# ADDITIONAL INFORMATION REPORT

MP 11\_0048

61 MOBBS LANE, EPPING – STAGE 2

MARCH 2012

Dec 21, 9am (Daylight Saving)

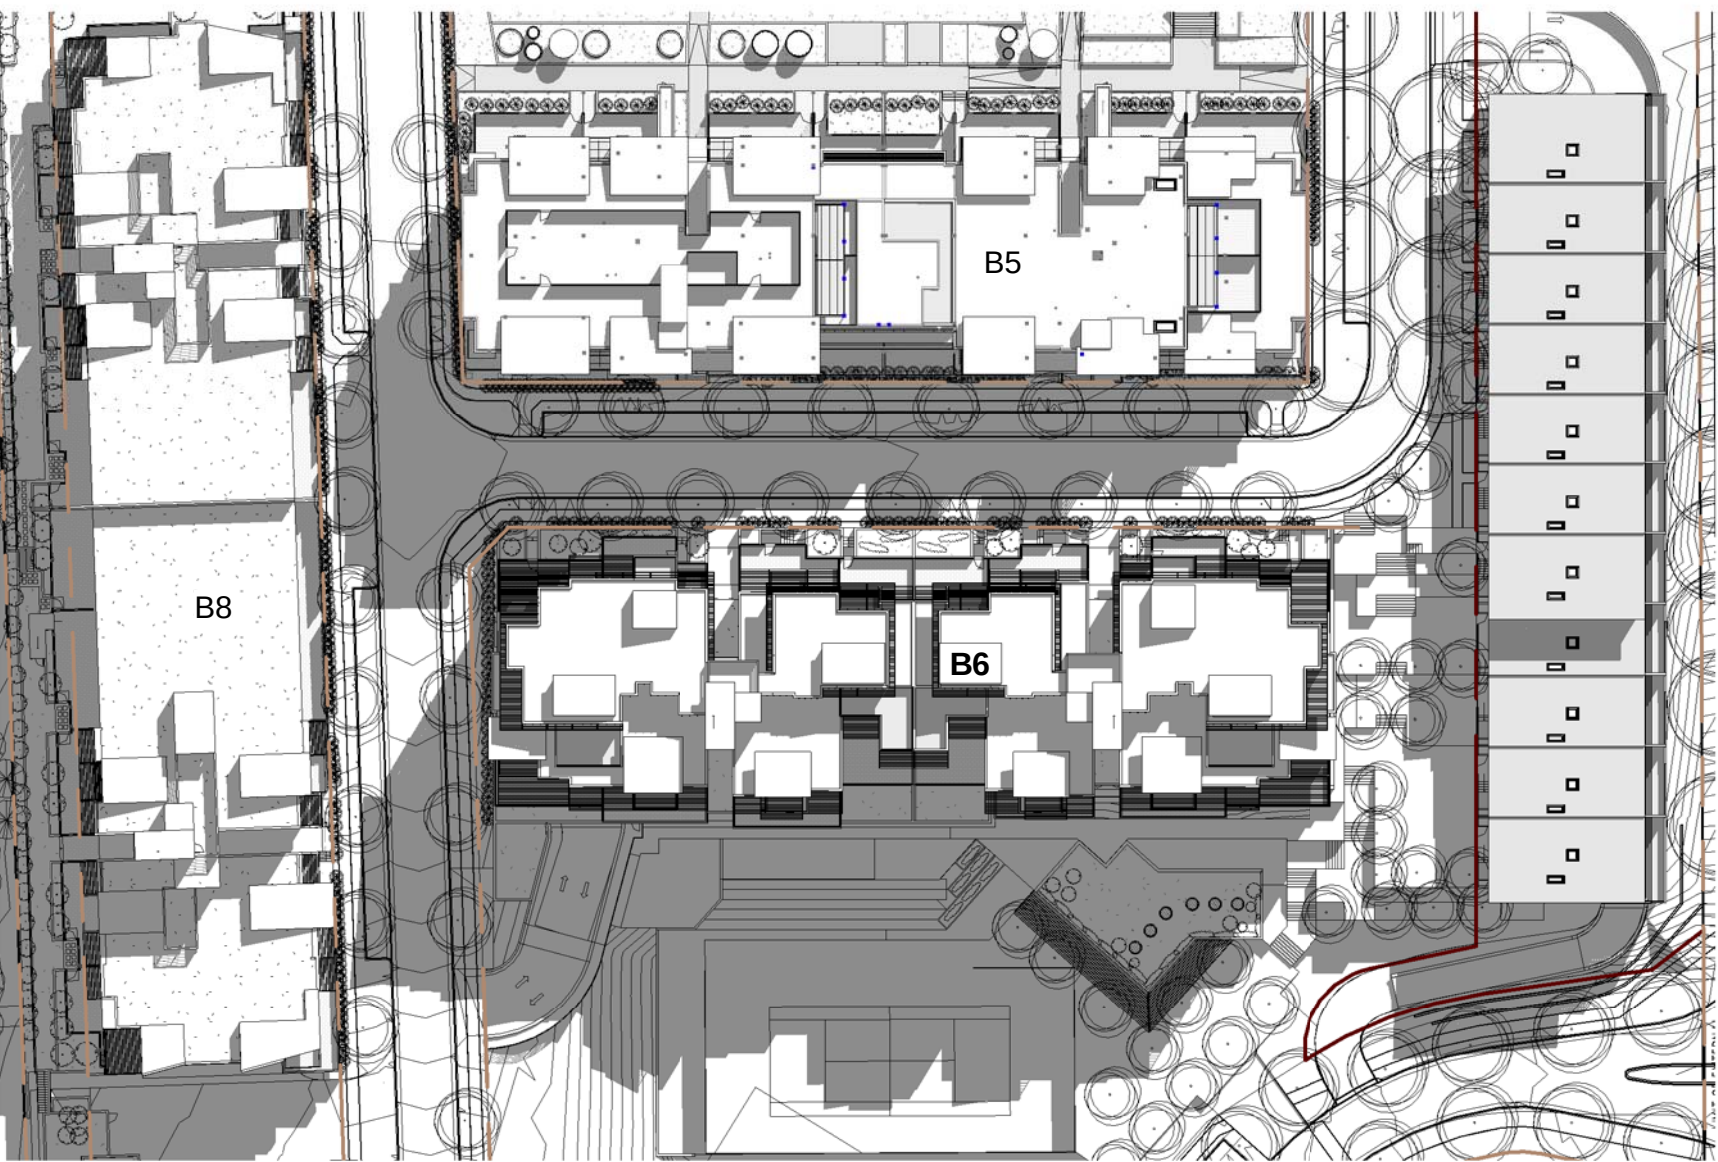
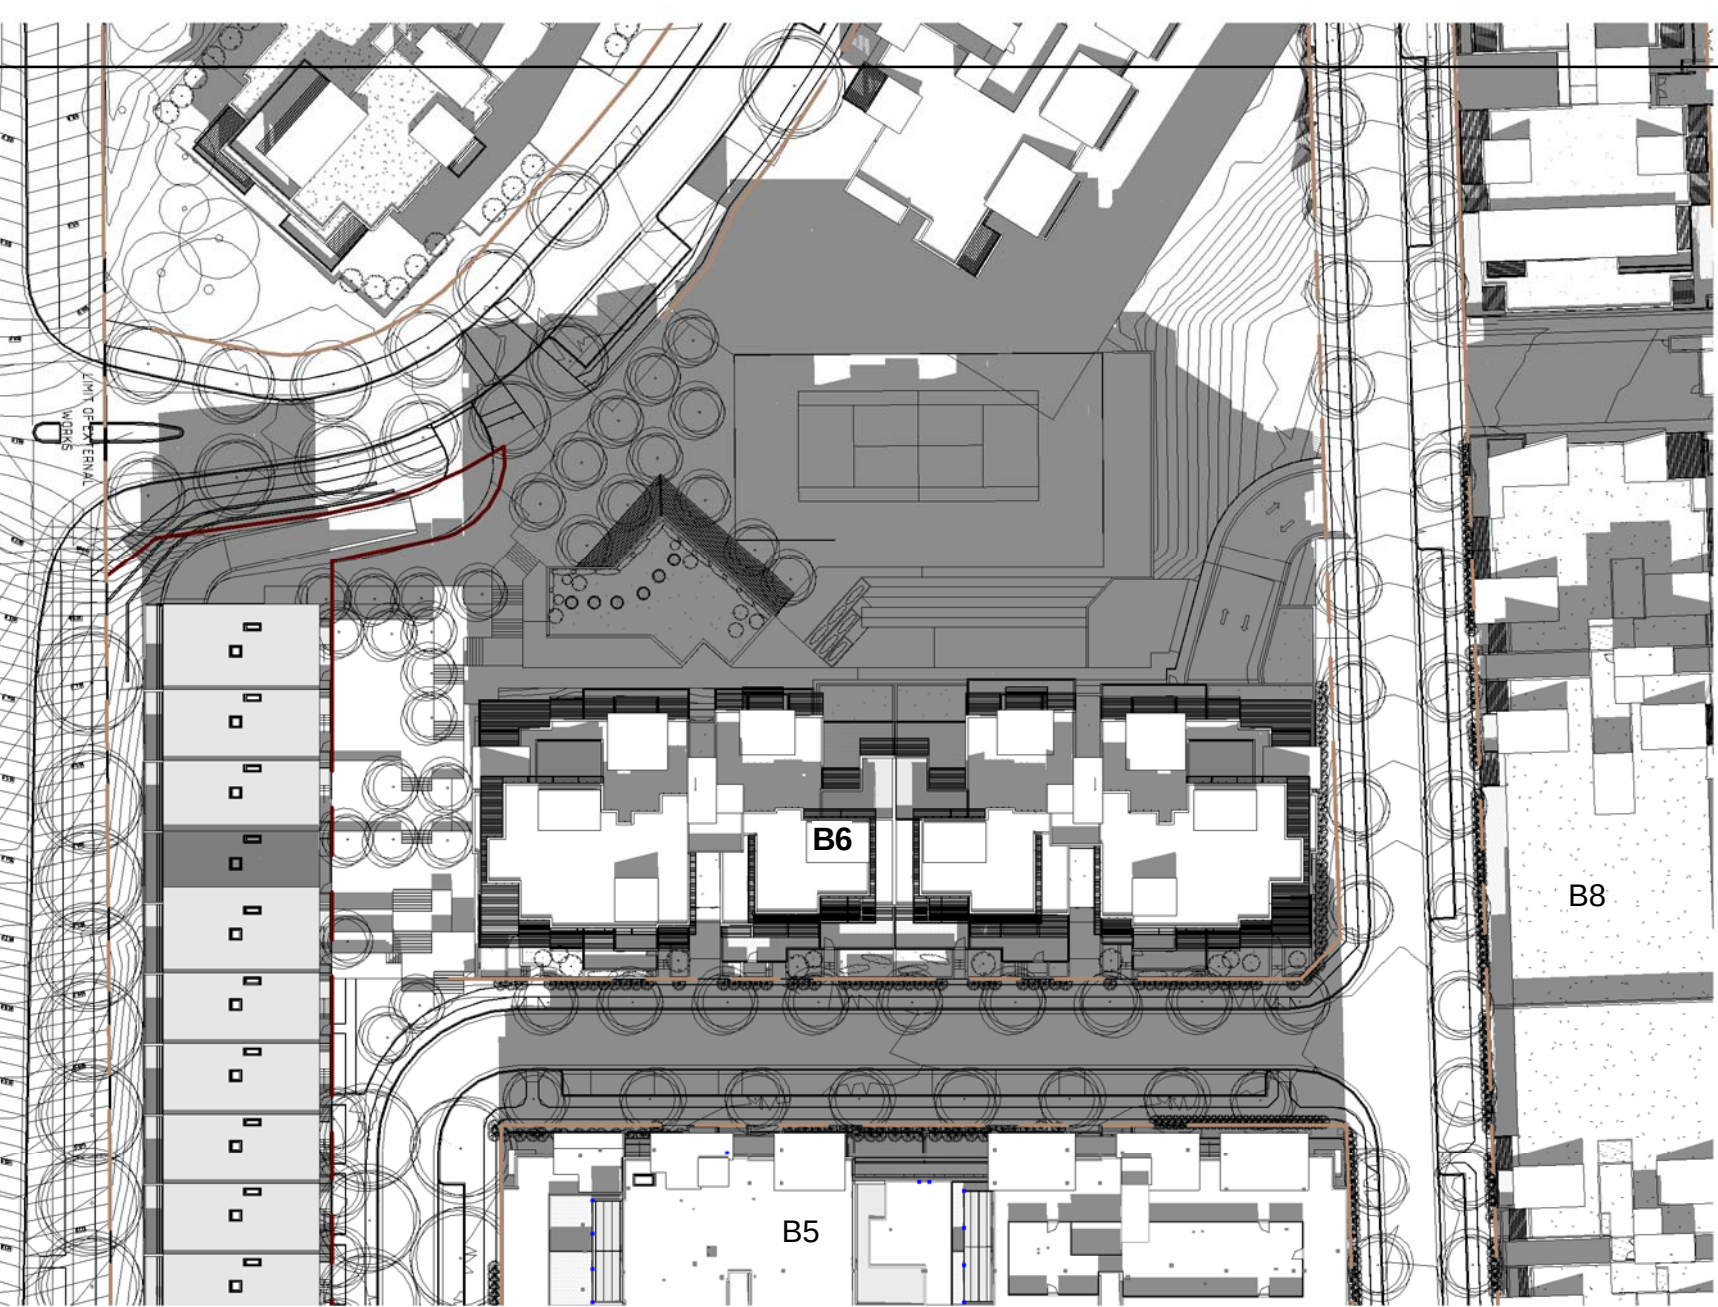
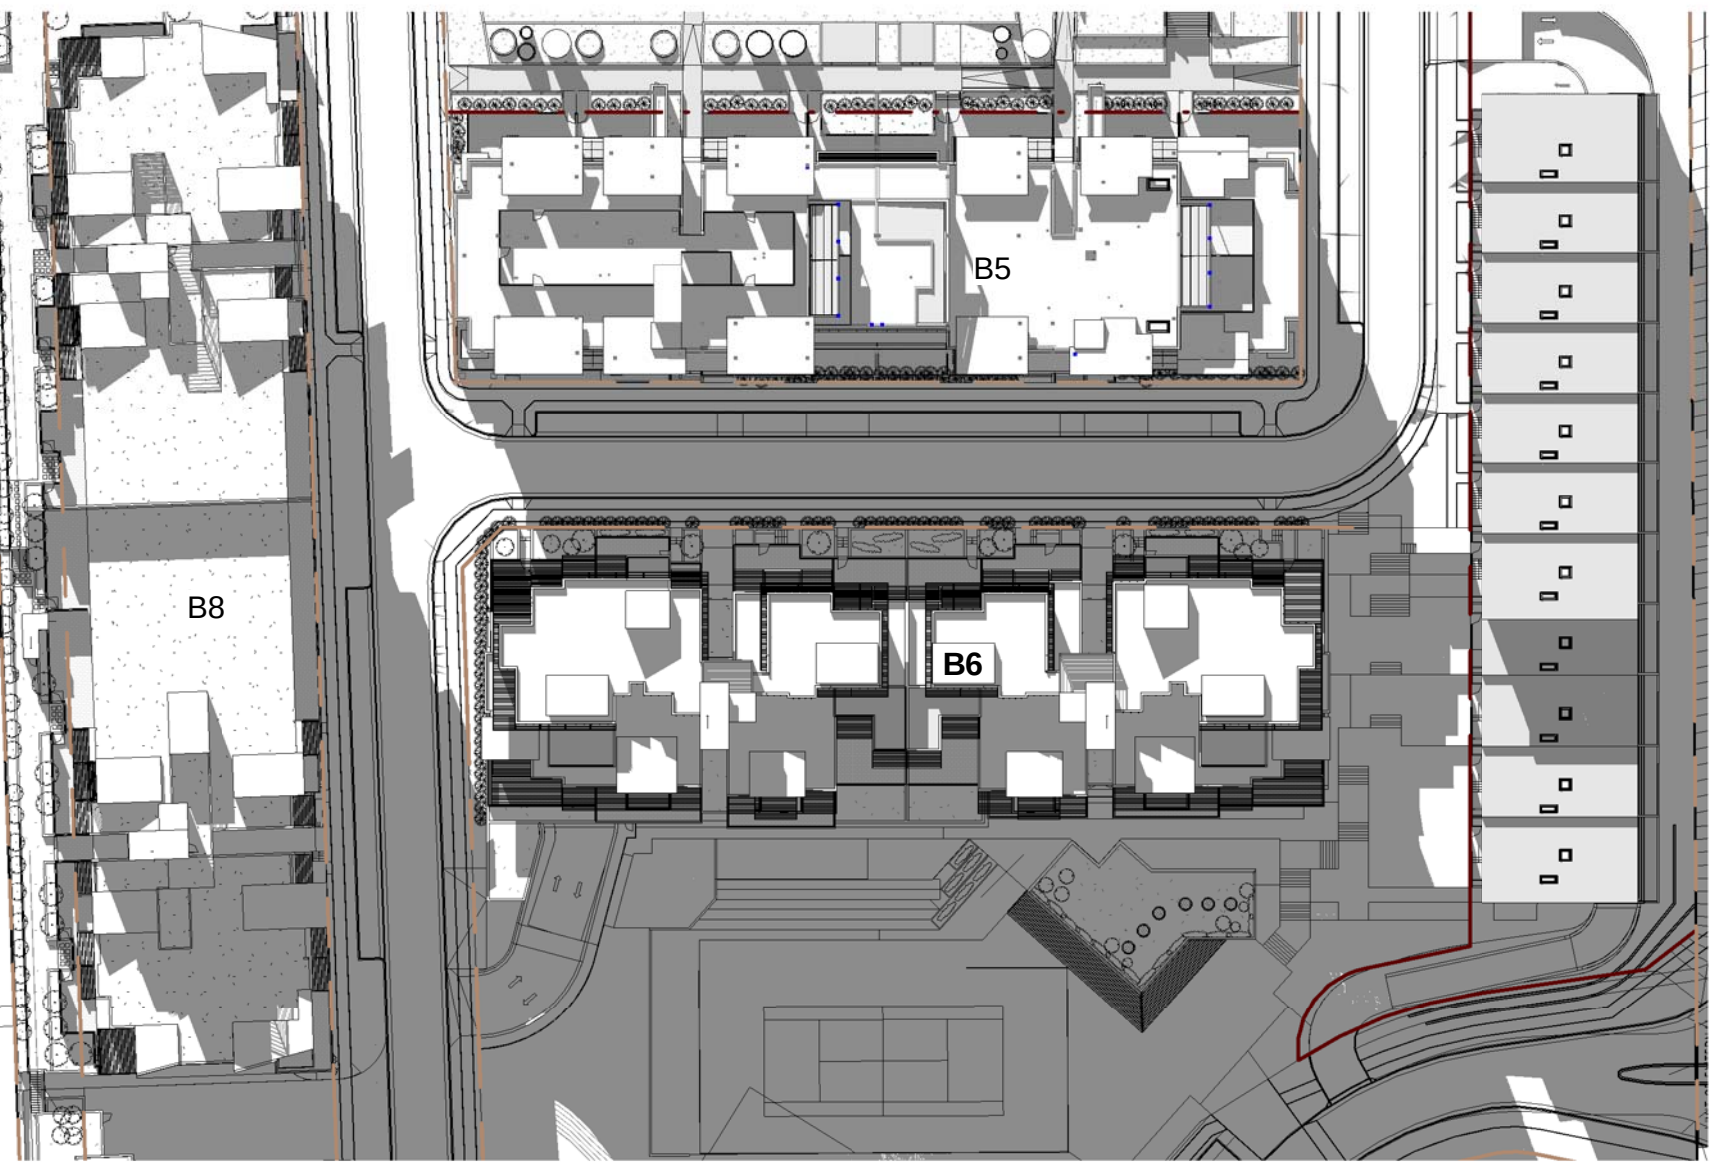
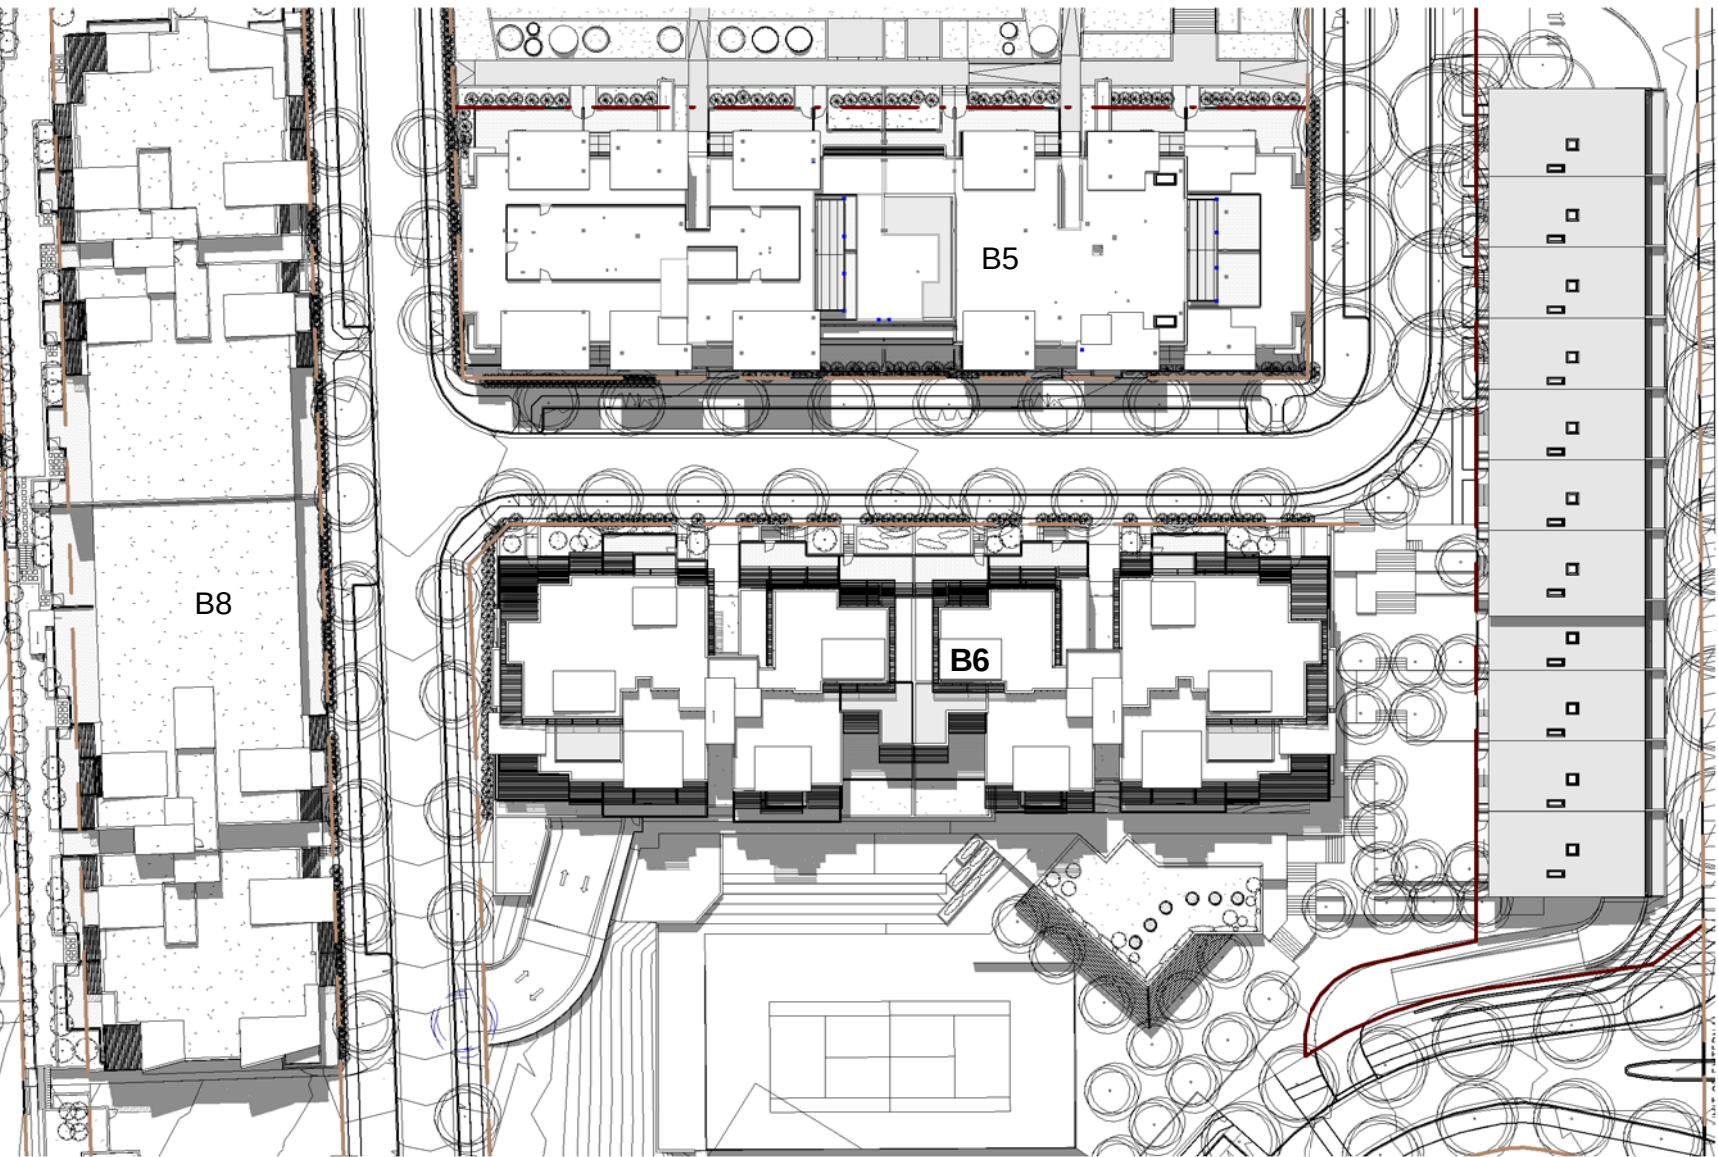
**Issue:** Shadow diagrams to be amended to include tennis court.

**Response:** Shadow plans have been corrected. Refer to ***Annexure 3***.
